Addendum No. 2

RE: Contract ID: C202915

WBS# 17BP.1.P.3

Bridge Preservation on Bridge #12, 25, 35, 47, 49 and 50 On US-13, #12 and 28 On NC-125
#7 On US-64, #14 On NC-11 and #42 On SR-1528

REVISIONS						SHEET NO.
NO.	BY:	DATE:	NO.	BY:	DATE:	S-33
1	DNS	2/12	3			TOTAL SHEETS
2			4			50

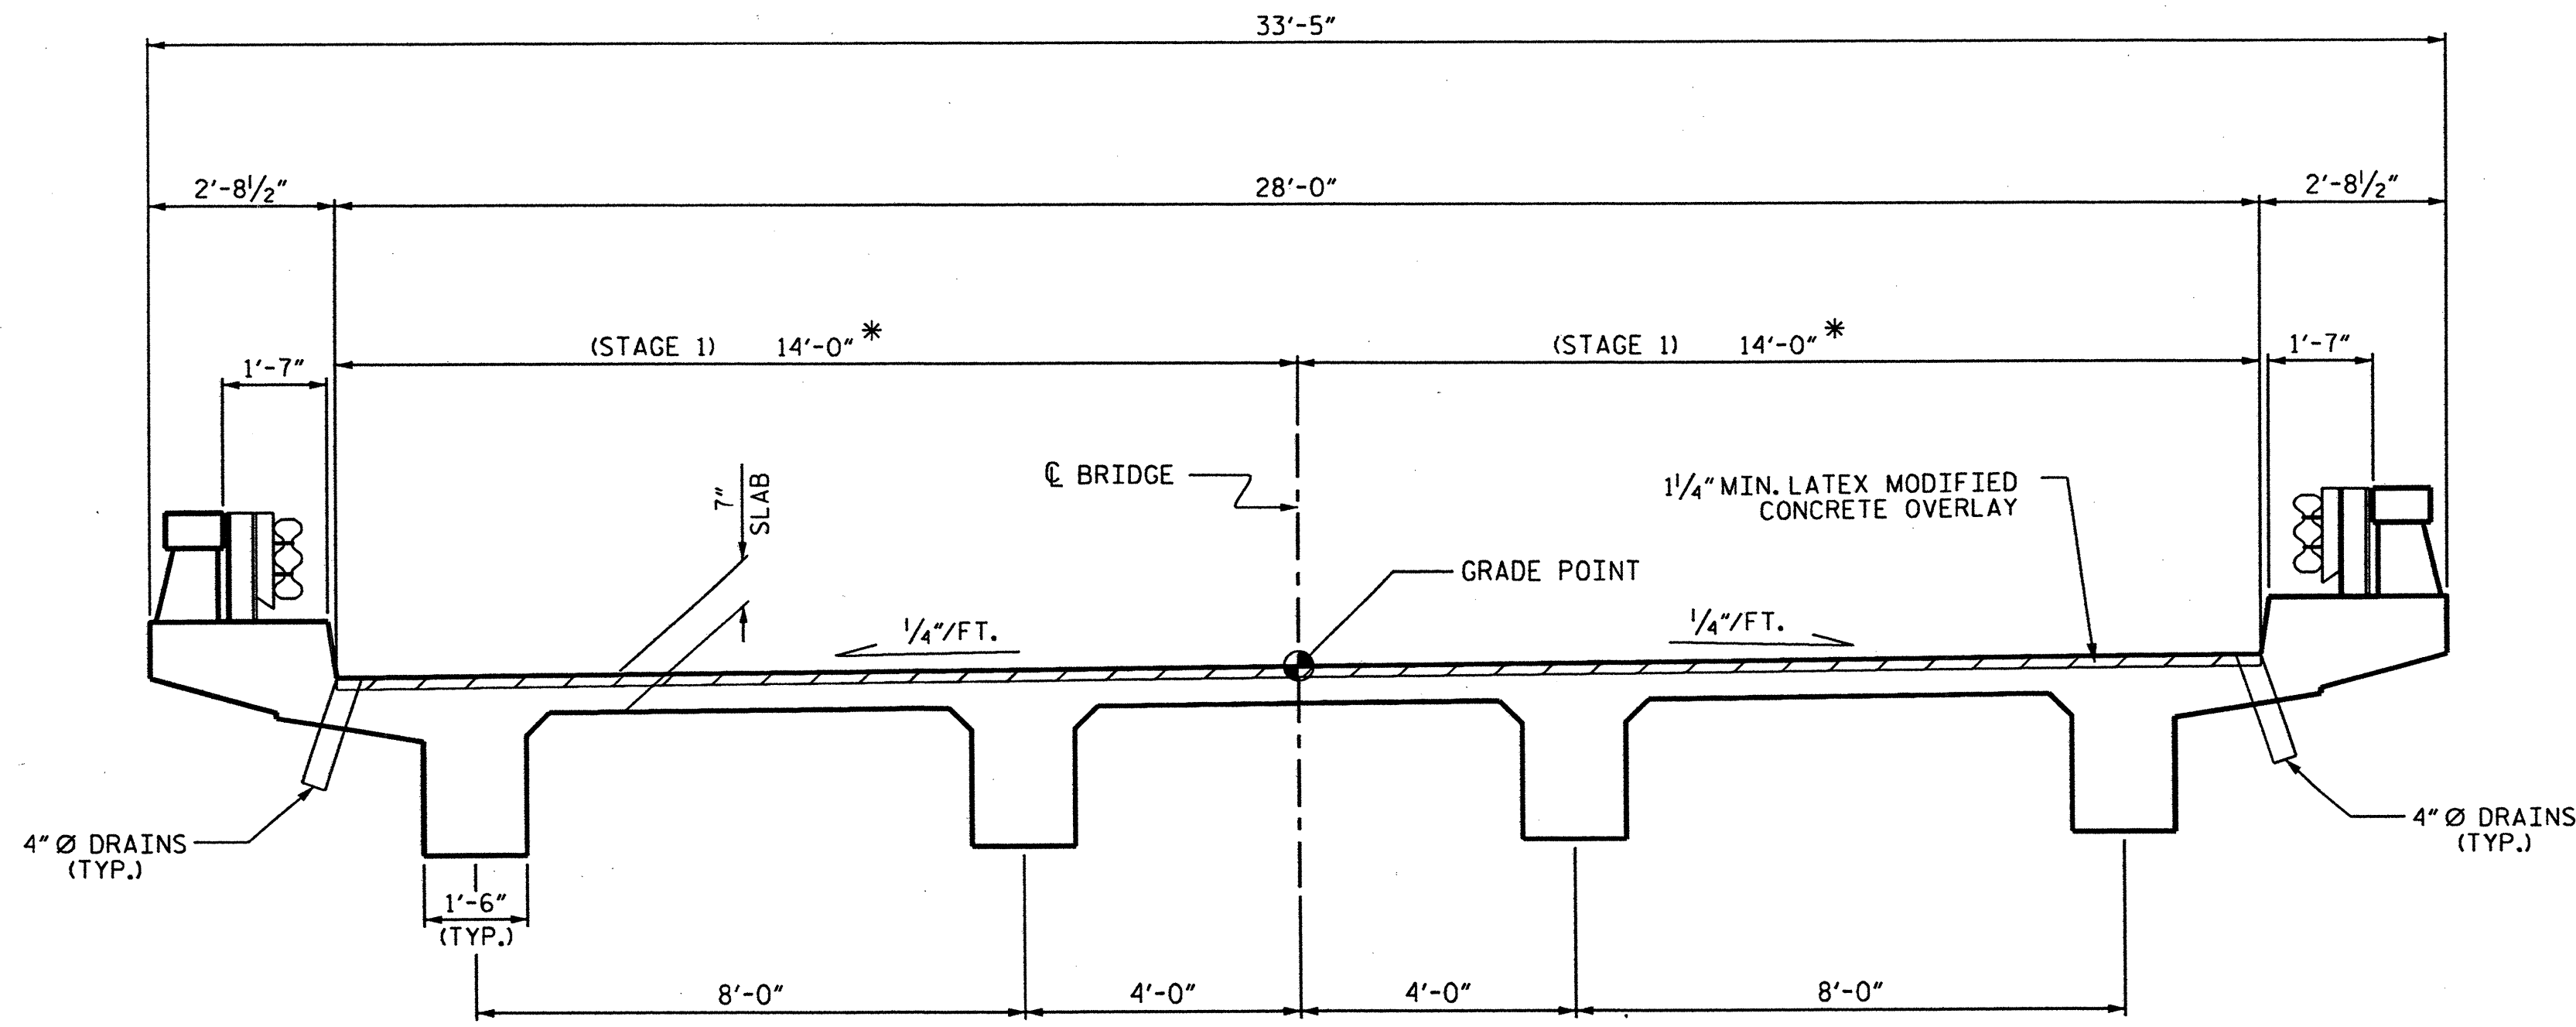
On Sheet No. S-33 the length of bridge floor has been revised. Please void Sheet No. S-33 in your plans and staple the revised Sheet No. S-33 thereto.
